From: Emily Delicata [REDACTED]
Sent: 19 September 2013 18:51
To: Cian Cronin
Cc: Dominic Smith
Subject: RE: Planning Consultation on: A/74/13/

SUBJECT: A/74/13

Proposed distribution warehouse and covered storage, trade counter and associated offices. Upgrading of access road for and improvement of existing junction with the A27. This application is a Departure from the Development Plan and affects a public Right of Way.

The Vinery, Arundel Road, Poling, Arundel, West Sussex, BN18 9PY

CLIENT	CHECKED LRA
	DRAWN BH
DRAWING PROPOSED SITE PLAN	DATE NOVEMBER 2012
	SCALE 1:500/2500 @ A1 1:1000/5000 @ A3
	REVISION A
	NUMBER 0764-PA-010

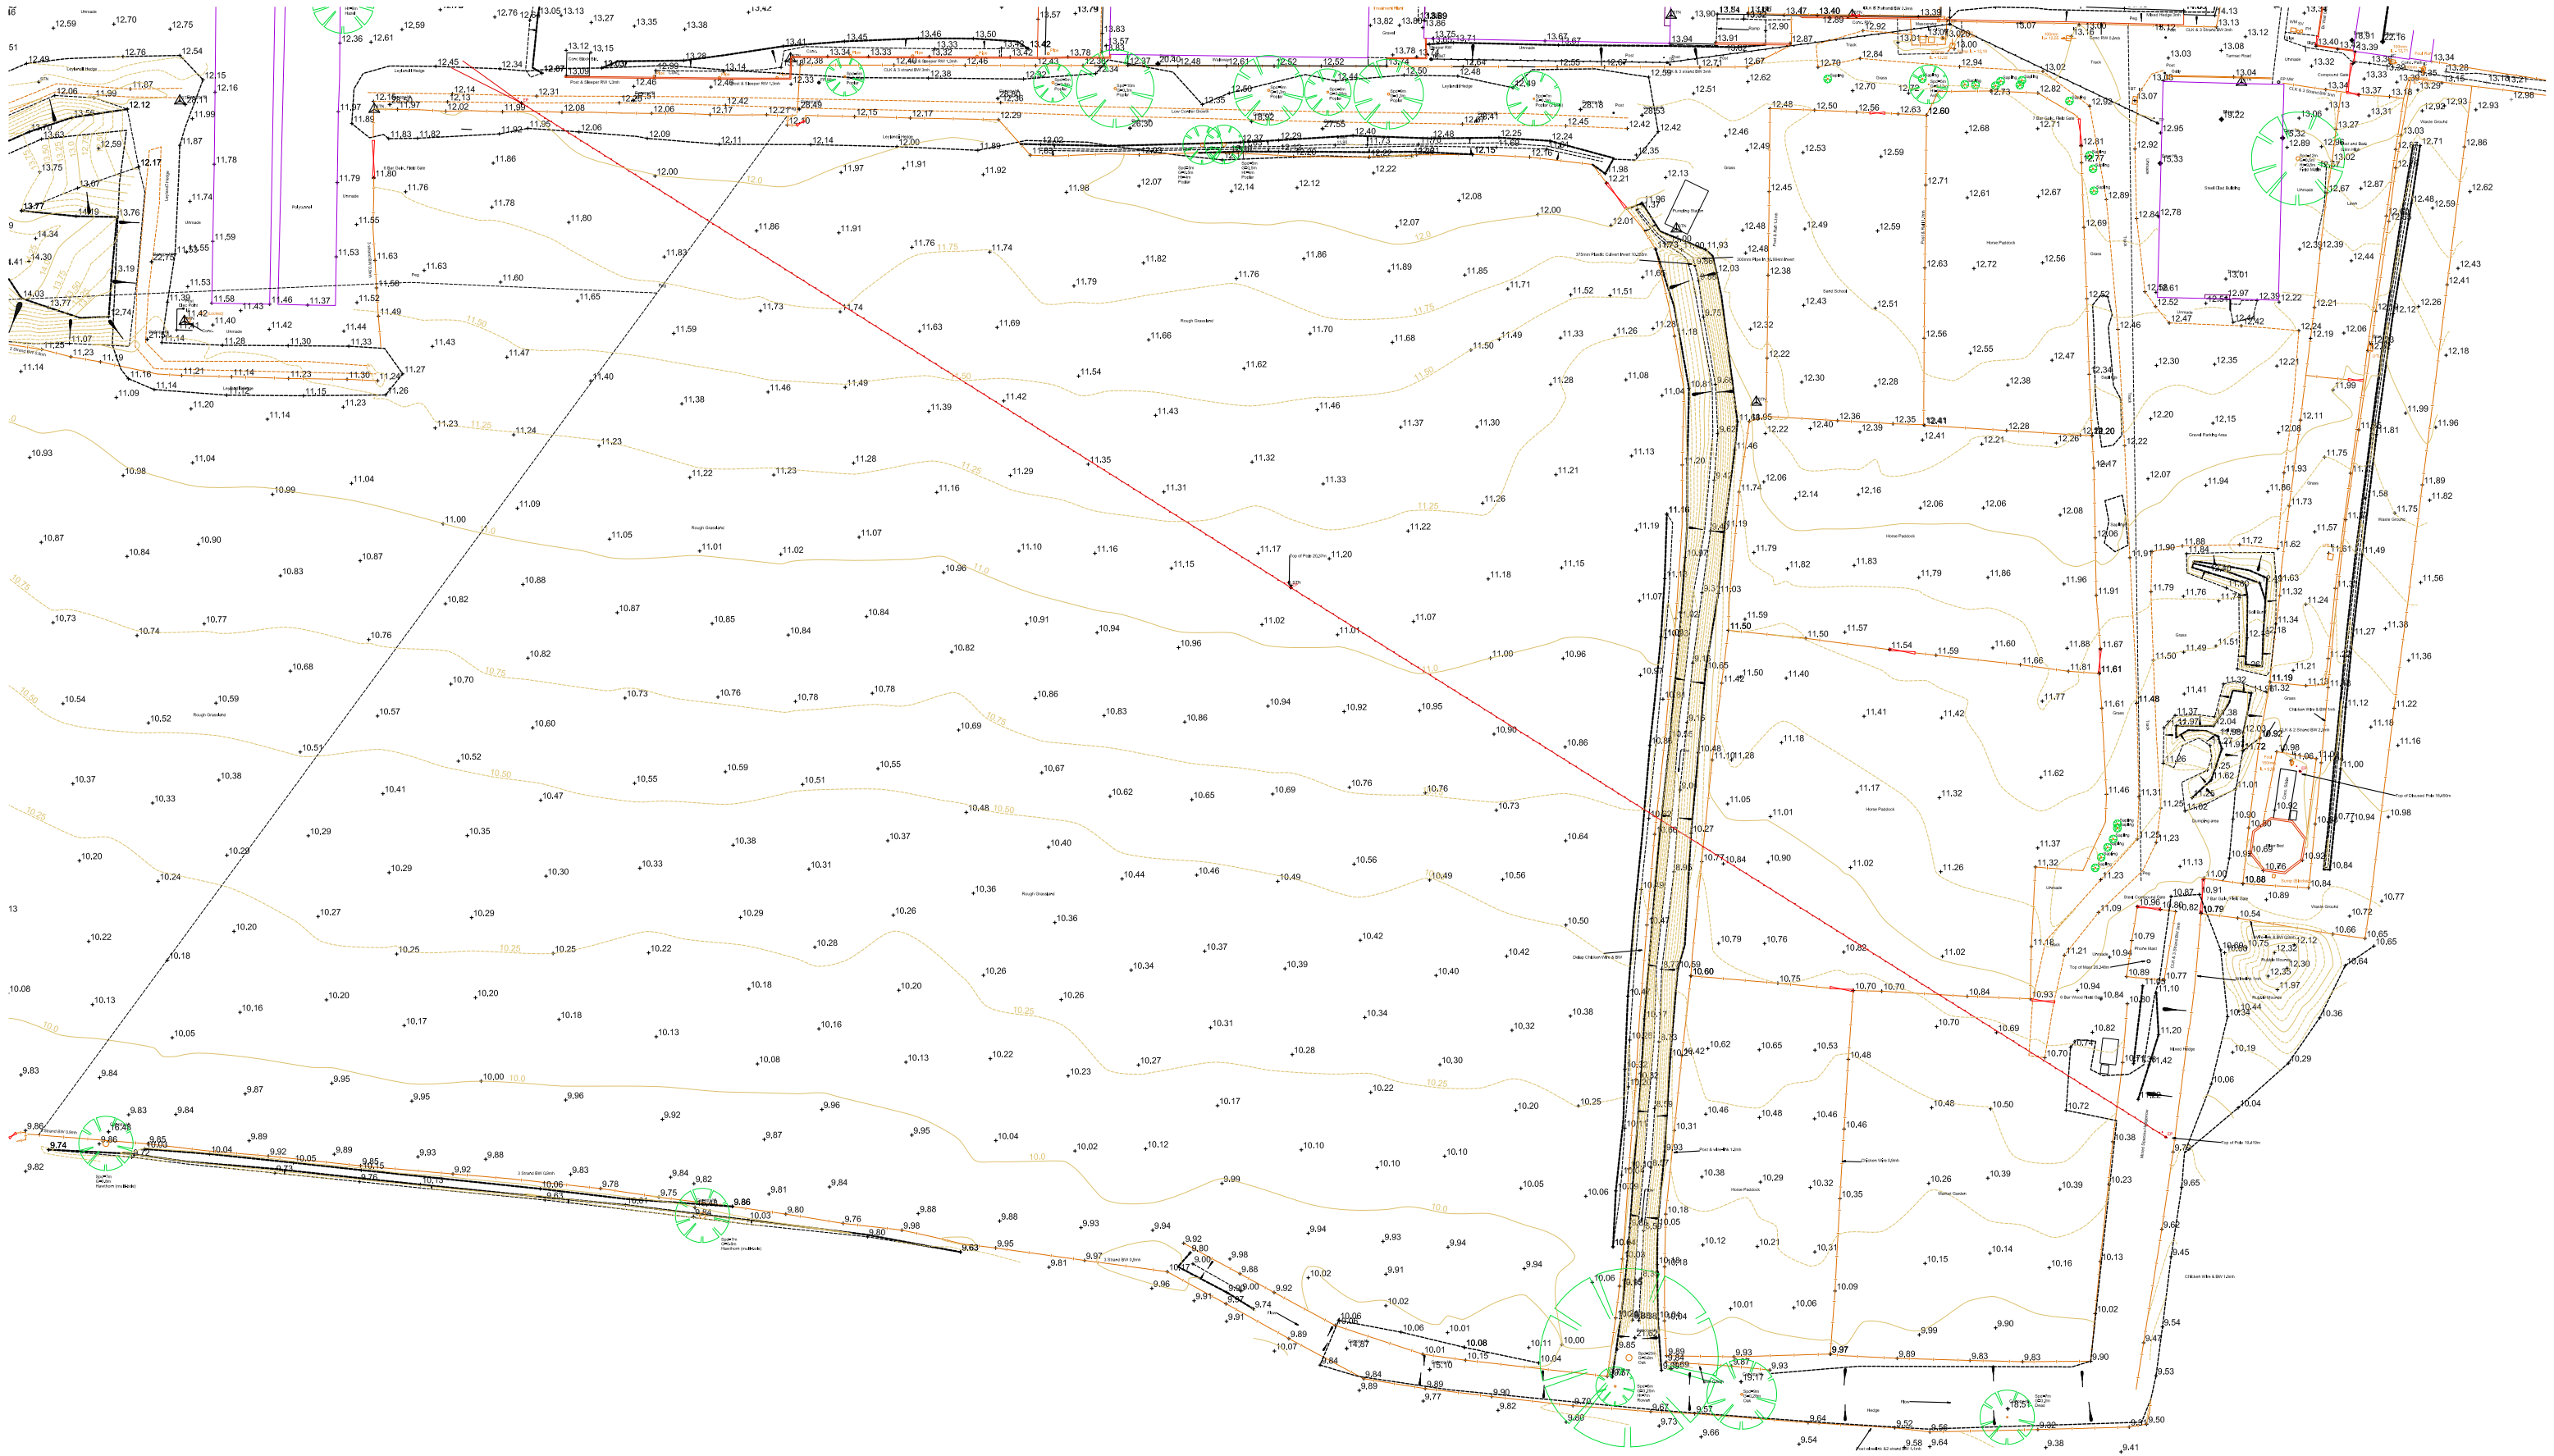
As has been recognised in these proposals the legal line of Public Footpath 2200 runs through the site and the proposed development and as far as can be made out from the plans has been incorporated within the designs and therefore should not be obstructed. It is likely that new signage will be required to make clear the legal line through the development and possibly signage for vehicles to be aware of pedestrians.
